CITY OF ALBUQUERQUE

November 15, 2022

**Re: El Encuentro Immigrant Community Center
907 4th St. SW
30-Day Temporary Certificate of Occupancy
Transportation Development Final Inspection**
Architect's Stamp dated 01-21-22 (K14-D121)
Certification dated 10-31-22

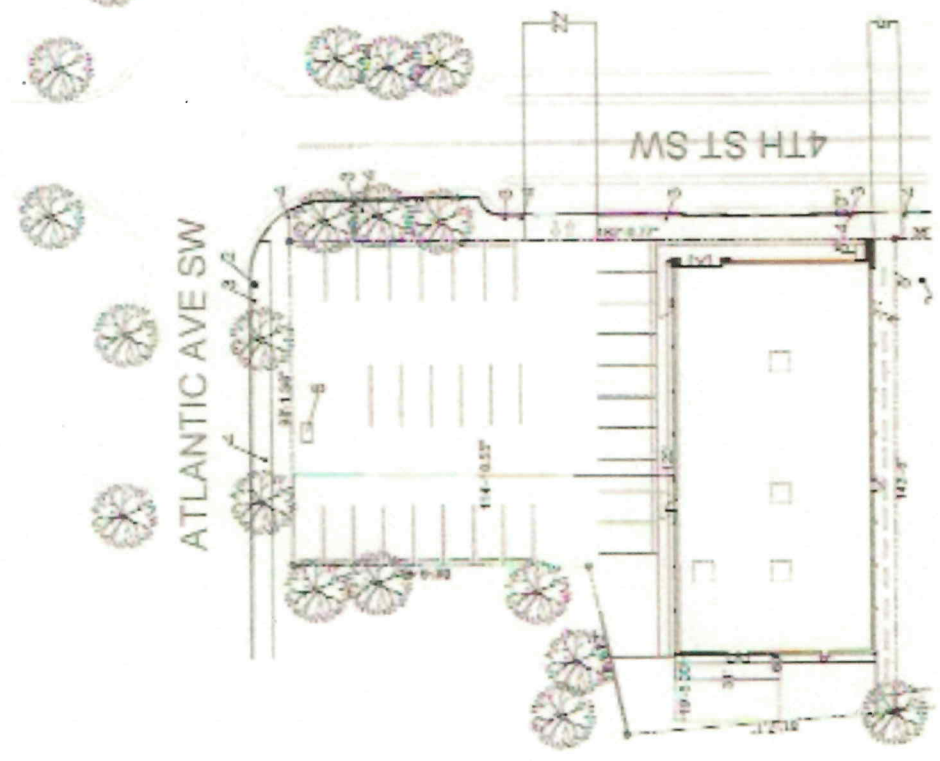
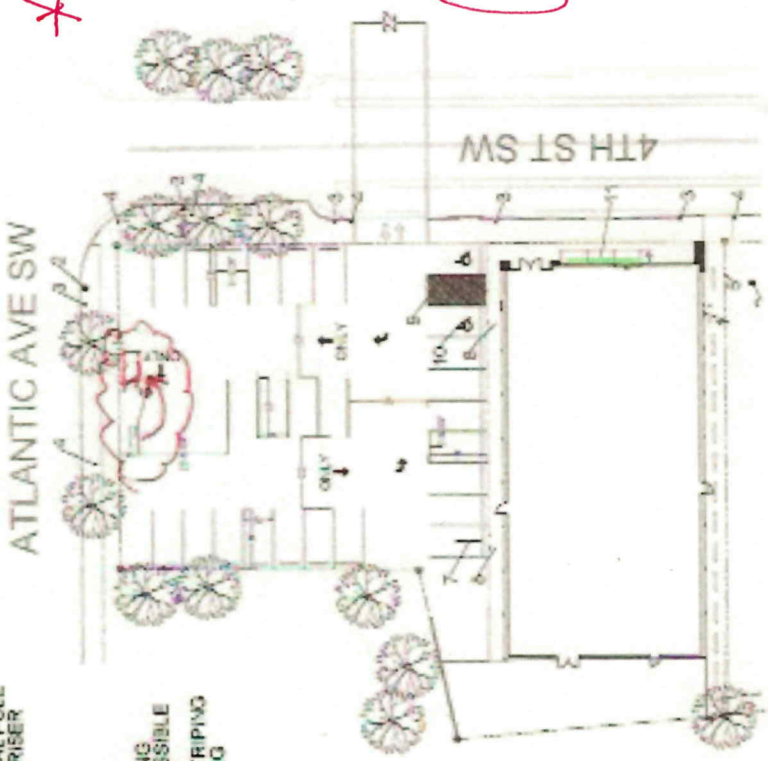
- Please provide City Right of Way improvements project number.
 - The new location of the Trash Bin is blocking one of the parking spaces. Please address this concern.
 - Please provide a written (or email) approval from the Solid Waste department about changing the location of Trash Bin.
 - Per approved site plan key note 9, a 6 ft. wide ADA pathway need to be provided from the ADA aisle to the building entrance.
 - "ONE WAY" and "DO NOT ENTER" signage need to be installed.
- Once these corrections are complete, email pictures to malnajira@cabq.gov for release of Final CO.
